From: Amanda Scholes on behalf of Planning.Responses
Sent: 11 June 2020 08:31
To: Planning Scanning
Subject: FW: BN/5/20/PL, Sunnyside Cottages

From: Maria Tomalova <Maria.Tomalova@arun.gov.uk>
Sent: 28 May 2020 10:07
To: Sarah Burrow <Sarah.Burrow@arun.gov.uk>
Subject: BN/5/20/PL, Sunnyside Cottages

The agent therefore pushed the proposed houses back and provided a Surface Water Drainage Supplementary Report, uploaded on The website on 19/05/20.

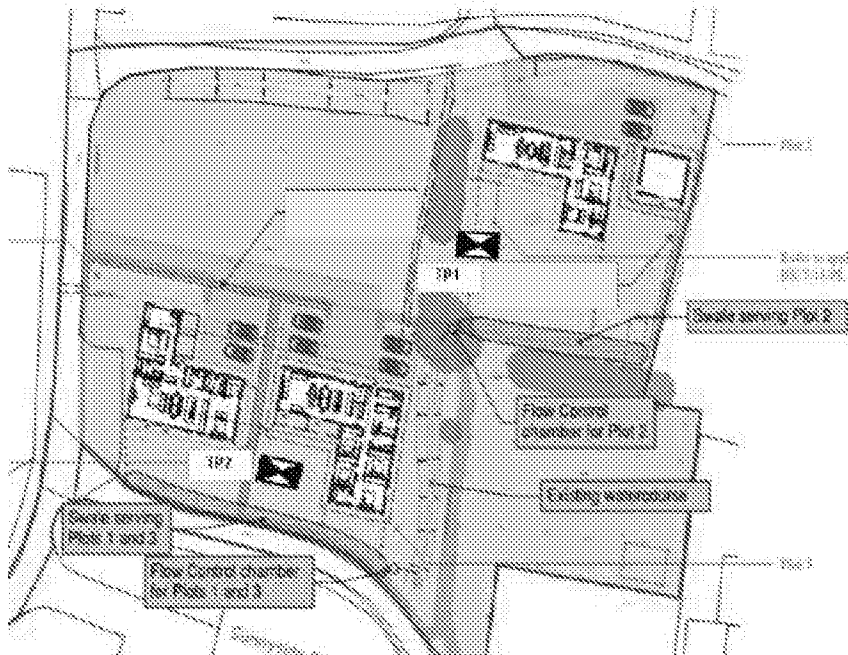
Whilst the explanation of the groundwater level is plausible, I am not comfortable with accepting a second hand verbal confirmation of this. The applicant will have to provide written confirmation from the company who undertook the testing that this is in fact how the results should be interpreted. An e-mail of such is fine.

Swale adjacent to Plots 1 and 3

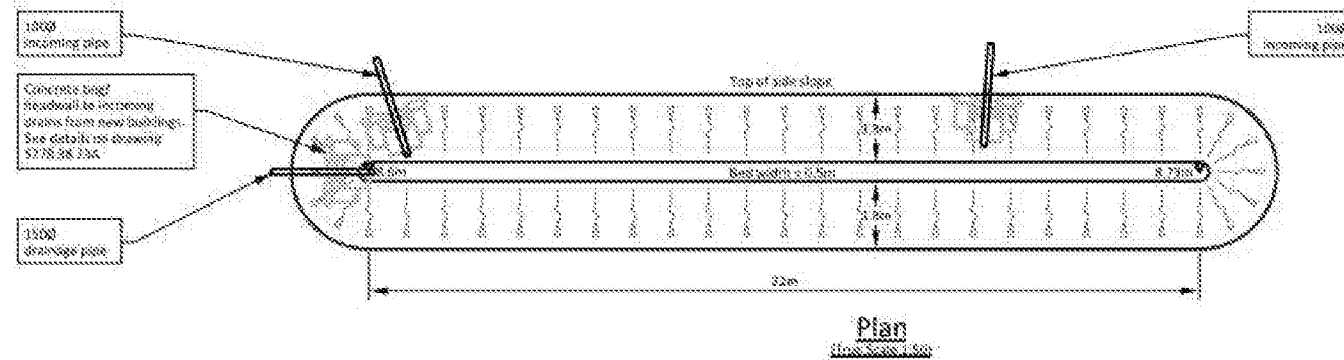
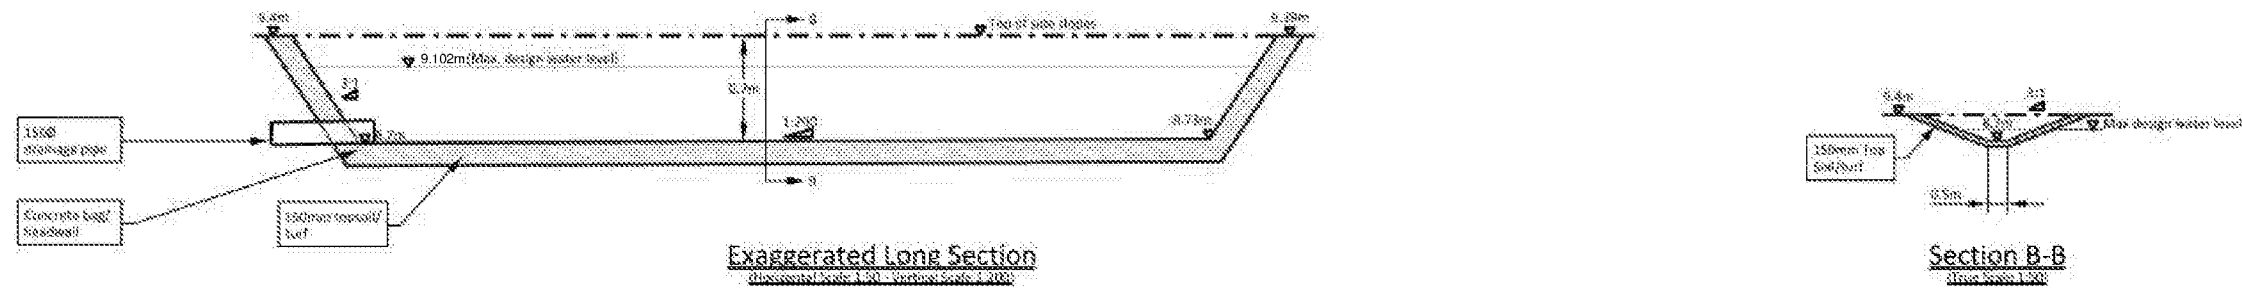
The calculations for the Swale for plots 1 & 3 use an impermeable area of 0.083ha instead of 0.0874ha (undersized by 44m³). I doubt that this will affect the design with any consequence but would like to see the actual impermeable area modelled please. The calculations are otherwise fine.
